Ribble Valley Borough Council
Housing & Development Control

Application no: **3/2021/0952**

Address: **Root Farm Dunsop Bridge Clitheroe BB7 3BB**

Proposal: **Demolition and conversion of farm buildings to employment space (Use Class E) including demolition of agricultural building and new build workshop.**

Client <b>The Duchy of Lancaster</b>			
Contract <b>Root Farm Dunsop Bridge</b>			
Drawing title <b>PROPOSED SITE LAYOUT &amp; BLOCK PLAN</b>			
Scale <b>1:500</b>	Job No. <b>KL2887</b>	Dwg No. <b>04</b>	<b>B</b>

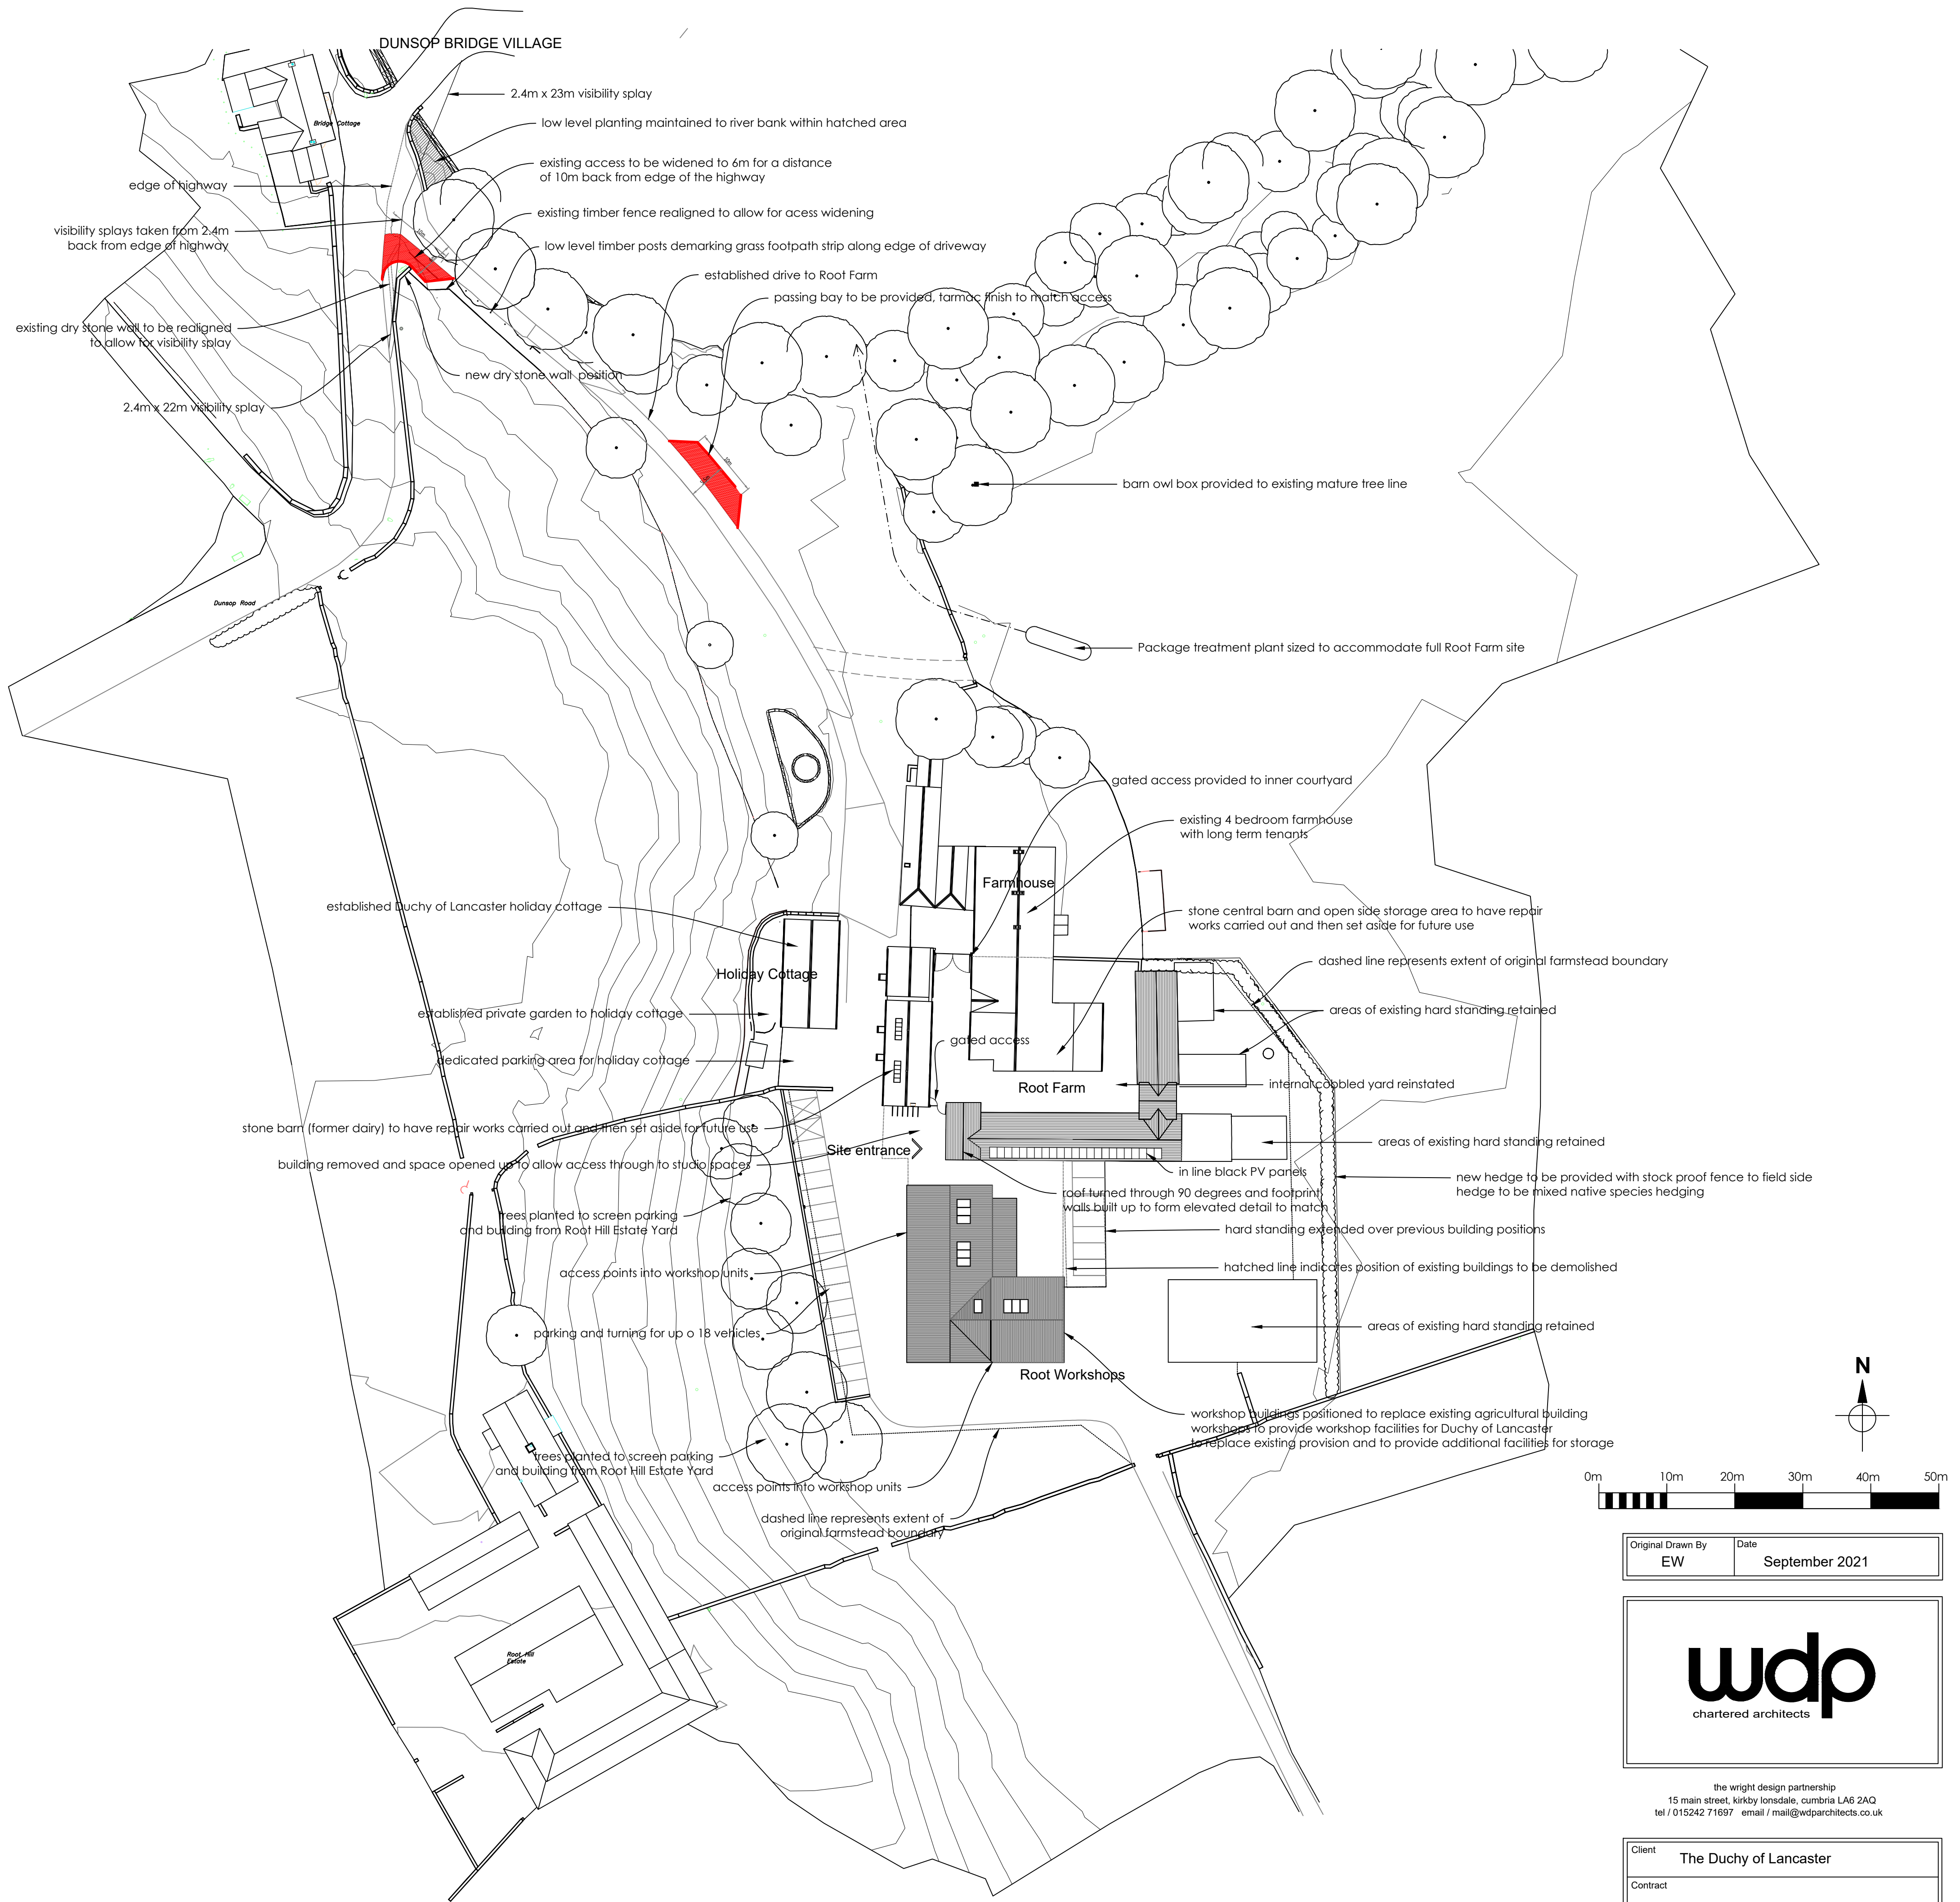
The LHA have reviewed WDP drawing number 04 titled "Proposed Site Plan and Block Plan" and understands that the site will be 9.2m wide as it meets the public highway. However, the LHA are unable to assess how wide the access track is at a distance of 10m from the public highway with the trees obstructing the view on the drawing.

The LHA reminds the Applicant that due to the intensification of use of the site following the proposal, the LHA require the access to be 6m wide for a distance of 10m from the public highway to comply with the LHAs guidance for a commercial site.

Furthermore, the LHA are also concerned about the useability of the access track which enters the site. This is because the LHA have measured the track at a

distance of 44m from the public highway and understands that the track is approximately 2.7m wide. Therefore, the LHA are concerned that large, delivery vehicles which could ultimately serve the proposed work units might not be able to use the access track. Not only this but there is no passing points along the track should two vehicles meet. This would prevent two-way movements occurring along the track leading to one of the vehicles having to reverse a significant distance to allow the vehicle to pass.

The LHA have reviewed WDP drawing number 04 titled "Proposed Site Plan and Block Plan" and understands that visibility splays of 2.4m x 22m to the left and 2.4m x 23m to the right have been provided at the site access. However, these visibility splays do not comply with the LHAs guidance titled "Creating Civilised Streets," with there being a shortfall in visibility by 3m to the left of the access.

While the LHA would normally accept the shortfall in visibility to the left of the access with it being minimal following the realignment of the existing wall, the LHA are unable to accept the visibility splay drawn to the right of the access. This because the splay is drawn over third party land which is not in the control of the Applicant. Therefore, the Applicant are unable to prevent these splays to be maintained in perpetuity and prevent any obstructions higher than 1m to be erected within the splay.

The LHA have conducted their own review and understands that the maximum visibility to the right of the access is likely to be 2.4m x 5m, as a result of the splay overlooking third party land. This is a shortfall of 18m from the LHAs guidance which is not acceptable. As a result, the LHA advise refusal on the grounds of the achievable vehicle visibility.

The LHA have reviewed WDP drawing number 04 titled "Proposed Site Plan and Block Plan," and understands that the site will provide 24 car parking spaces for the proposal.

The LHA have also reviewed the access track into the site and are concerned about where large, delivery vehicles will turn around when exiting the site. This is because there appears to be no turning facilities provided.

Furthermore, the LHA have reviewed the detailed notes on the drawing and understands that two of the agricultural buildings, one adjacent to the holiday cottage and one adjacent to the farmhouse will be renovated for future use. However, the Applicant has failed to state the type of use the buildings will have. Therefore, for clarity the LHA would expect the Applicant to state what the future use of the buildings would be. This is so the LHA can assess whether the future use of the buildings will conflict with the day to day operation of the proposal.
